WEST SUSSEX COUNTY COUNCIL CONSULTATION

TO:	Arun District Council FAO: Simon Davis
FROM:	Highways, WSCC: Tim Townsend
DATE:	7 th January 2019
LOCATION:	Land off, Burndell Road, Yapton, Arundel
SUBJECT:	Y/102/18/DOC Approval of details reserved by condition imposed under ref APP/C3810/V/16/3158261 relating to Condition No 13 Construction Management Plan.
DATE OF SITE VISIT:	
RECOMMENDATION:	☒ Advice ☐ Objection ☐ Modification ☐ No Objection ☒ More Information ☐ Refusal
S106 CONTRIBUTION TOTAL:	£N/A (secured as part of outline planning permission).

Construction Traffic Plan

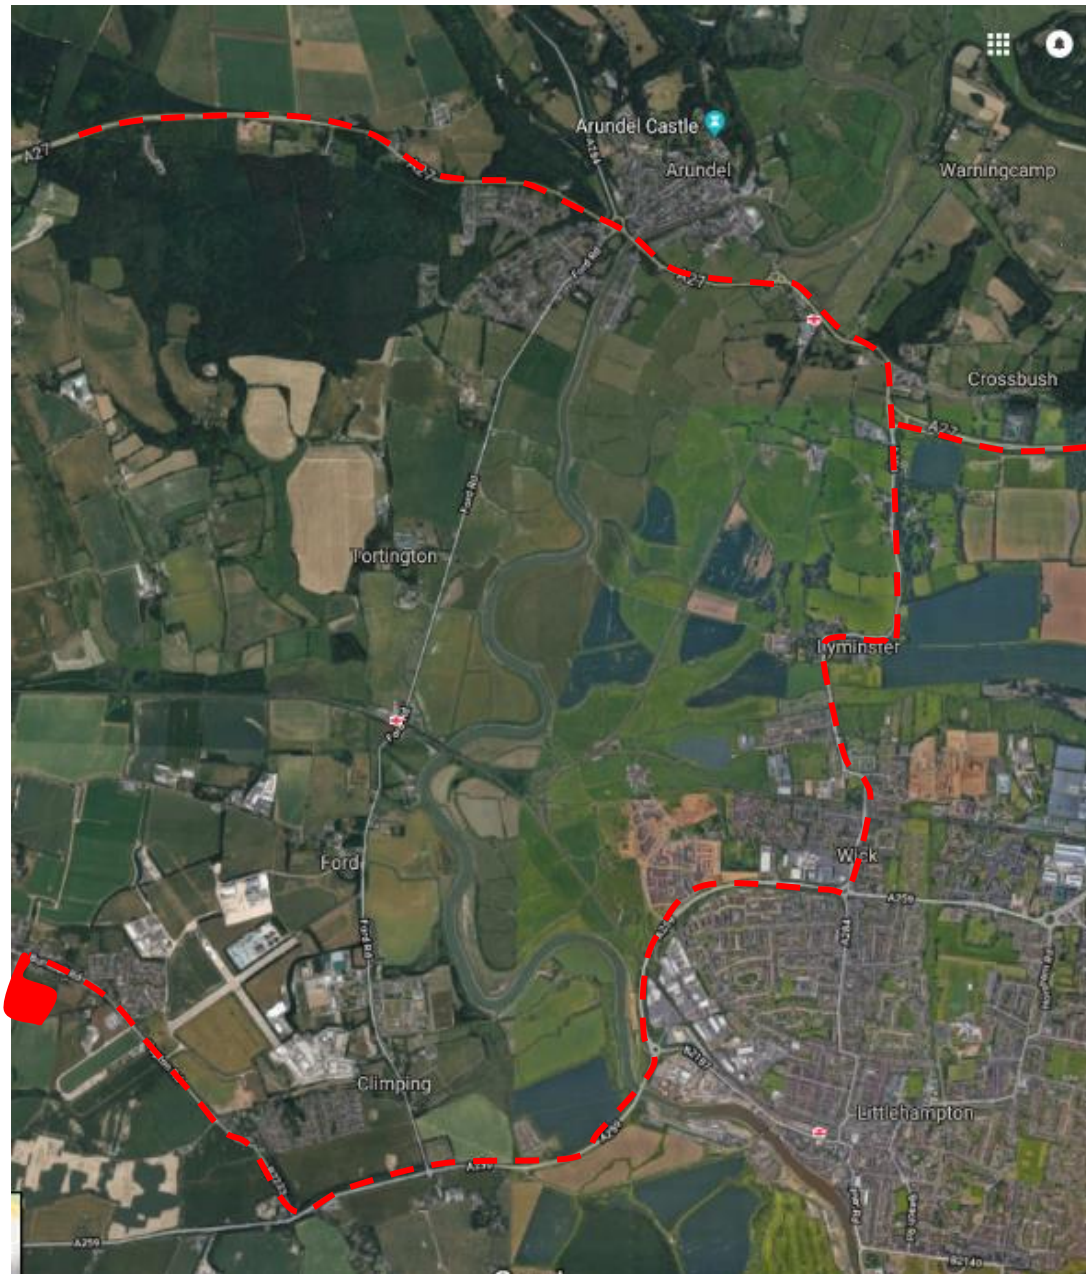
- Section 2 "Method access and routing etc."** - Condition 20 of the planning consent requires the access and associated works onto Burndell Road to be completed prior to works commencing on-site. Therefore, anything approved under condition 13 should not override this requirement. Also, an off-site road routing plan should be submitted. Finally, a detailed plan showing the location of the site hoarding adjacent to the access (and how this impacts on access and visibility splays) should be shown on a detailed plan.

SITE COMPOUND

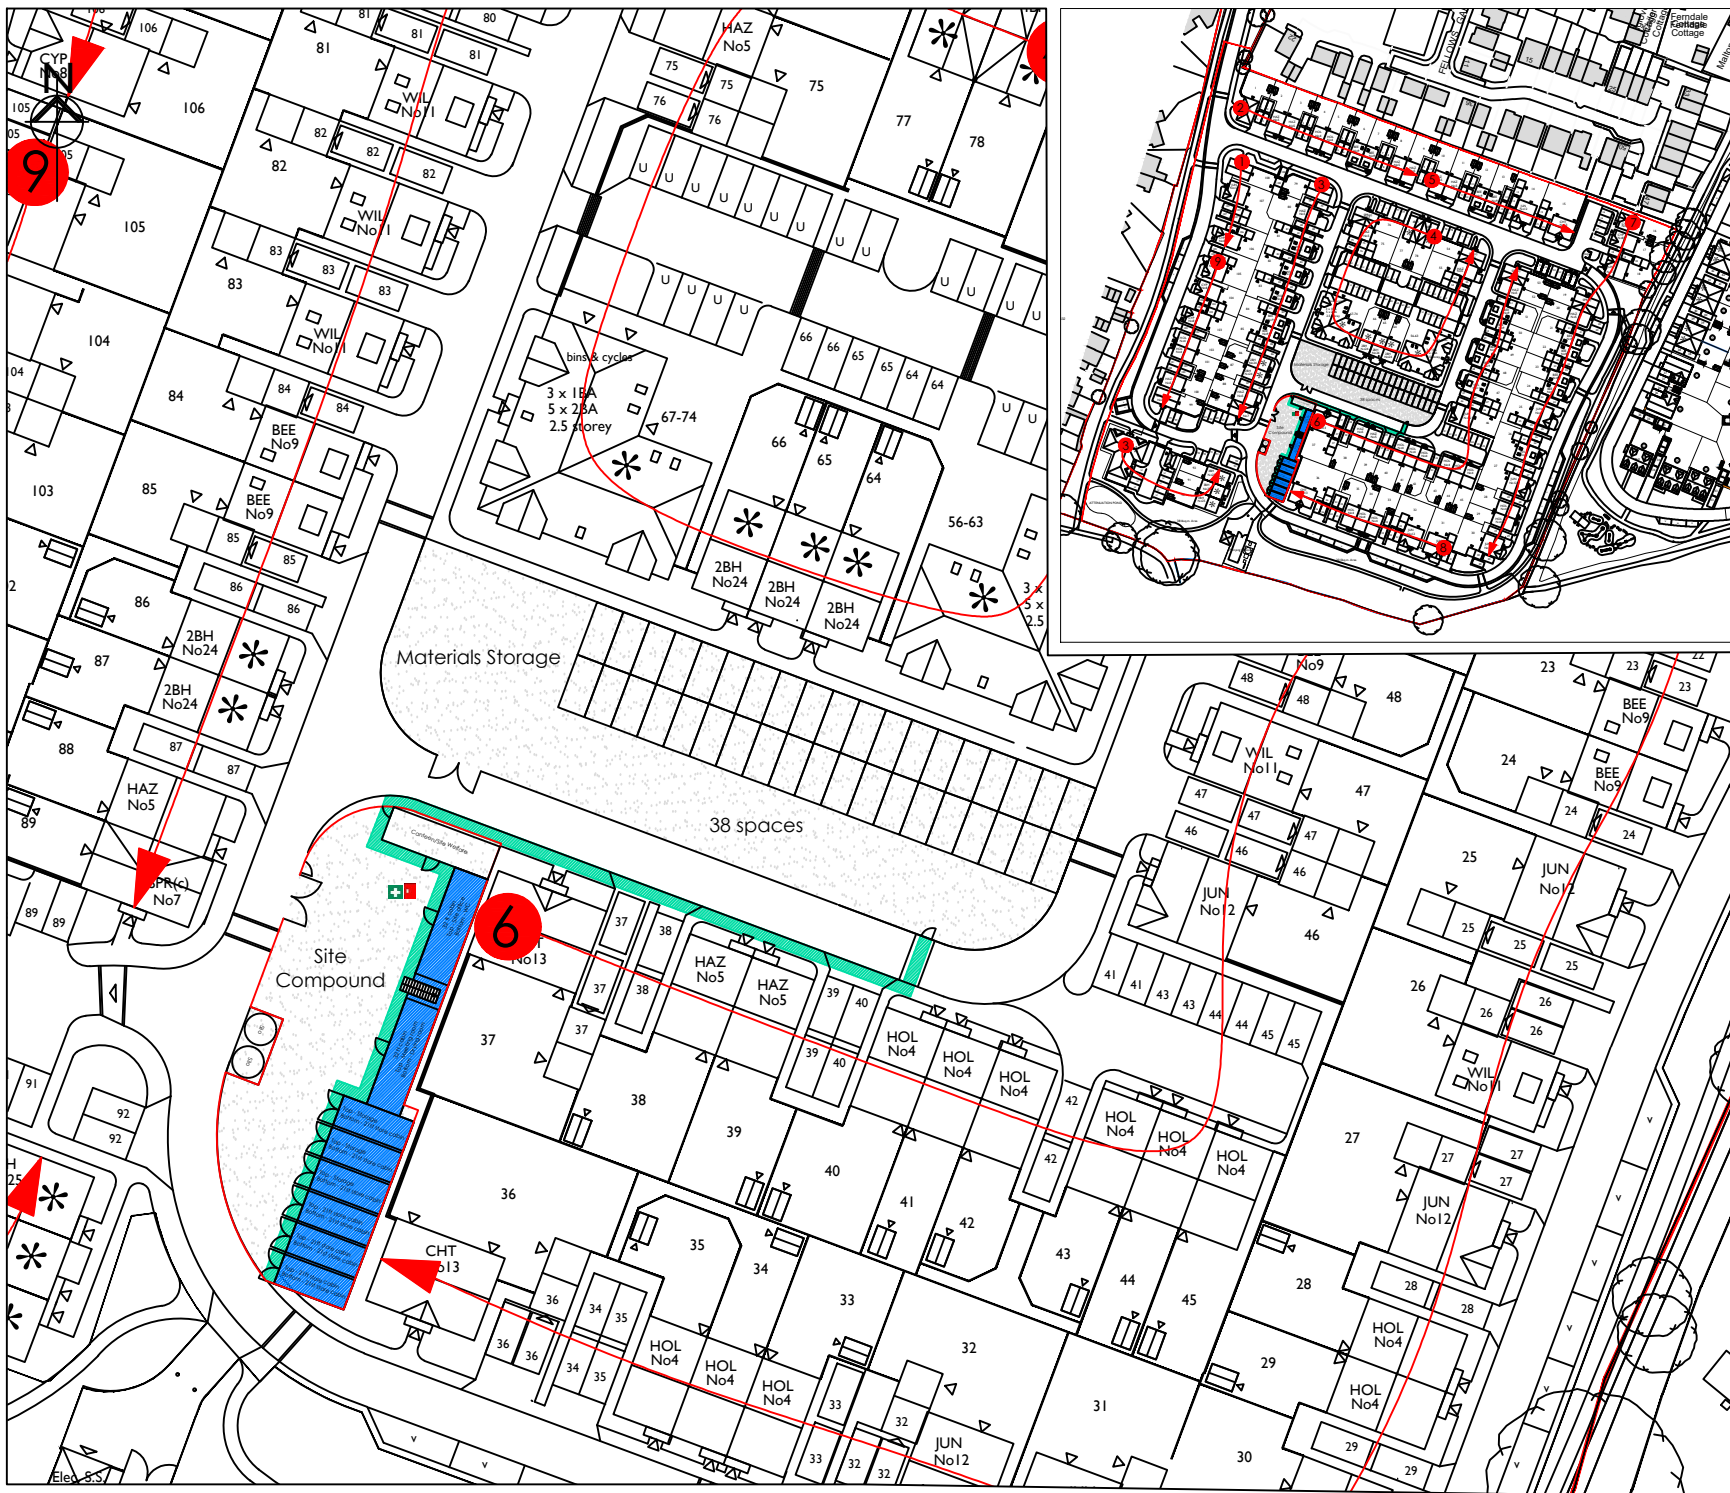
- Section 3 "The parking of vehicles etc."** - As well as no delivery vehicles being permitted to park or lay-up on adjacent roads, the CMP should also state that no operatives or visitors should do this either and all be accommodated within the site. The applicant should also confirm that all vehicles will be provided with adequate on-site turning and that they will only enter and leave the highway in a forward gear.
